**EL PASO COUNTY PLANNING AND
 COMMUNITY DEVELOPMENT
 DEPARTMENT**

GRADING AND EROSION CONTROL PLAN CHECKLIST

SHEET 5 OF 10
 JOB NO. 25188.00

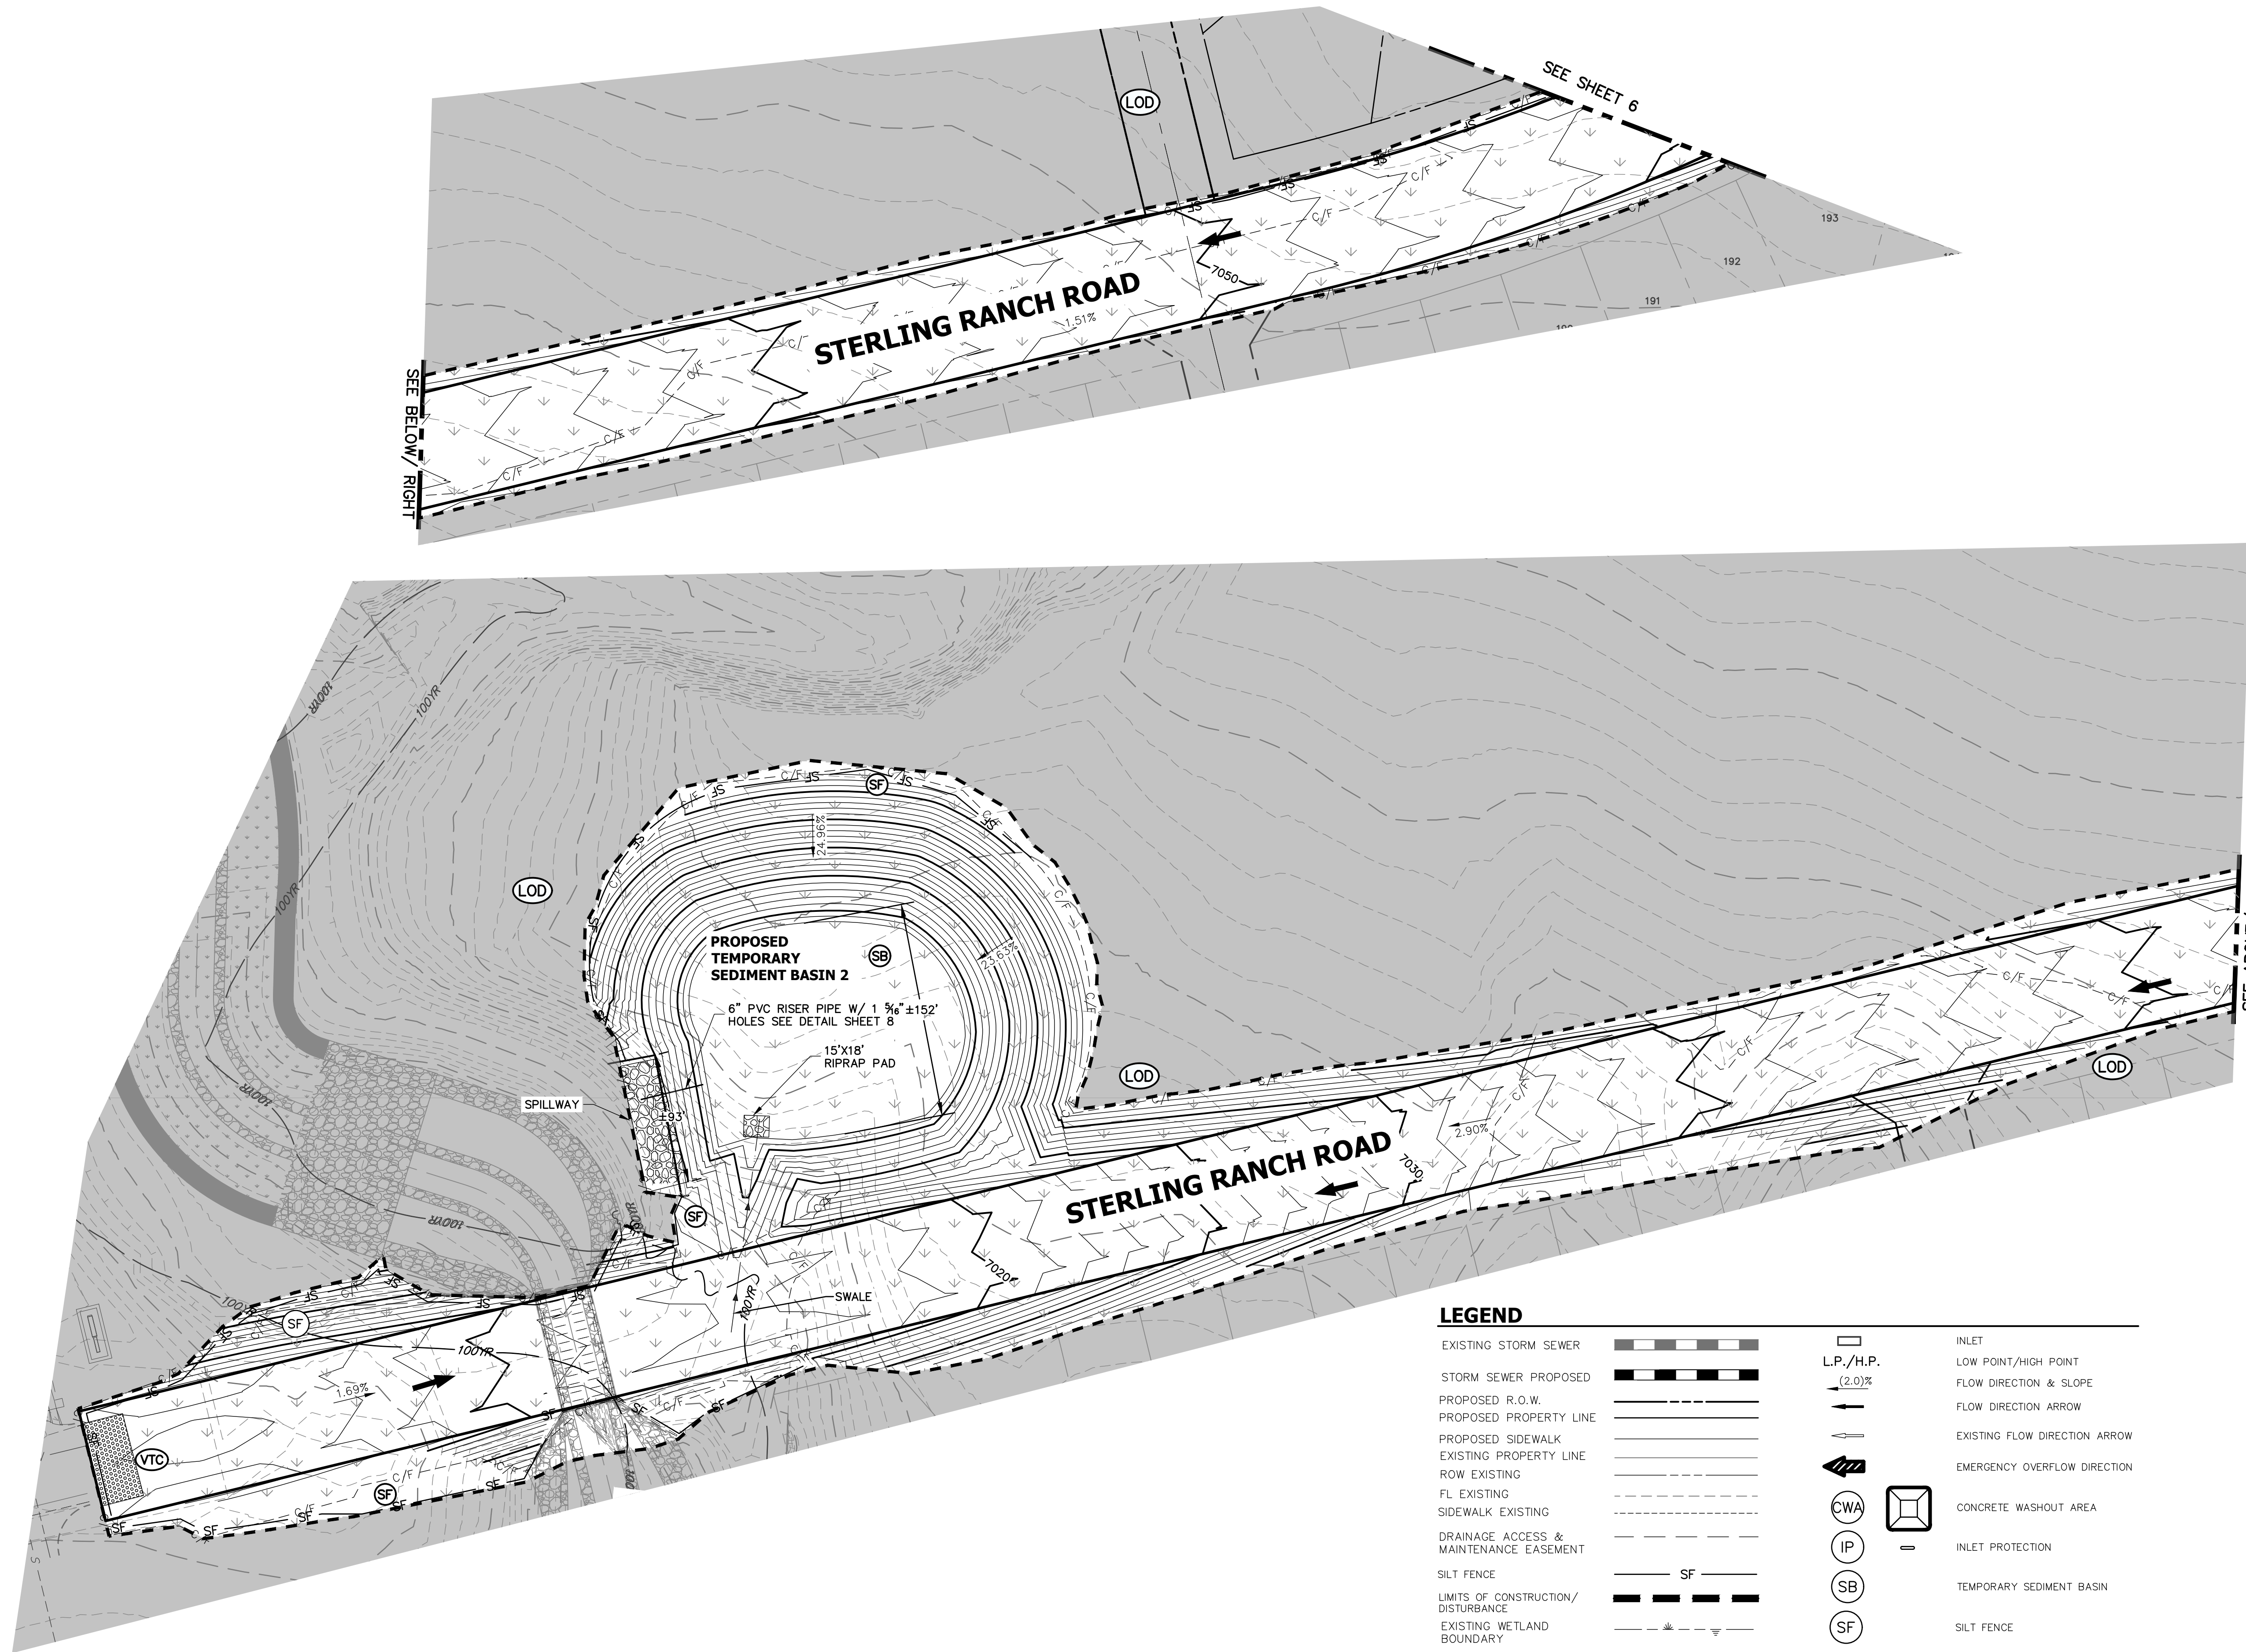
| | | Applicant | PCD |
|--|---|-----------|-----|
| z | All proposed temporary construction control measure details. Custom or other jurisdiction's details used must meet or exceed EPC standards. see comments on Sheet 5 | Y | ✗ |
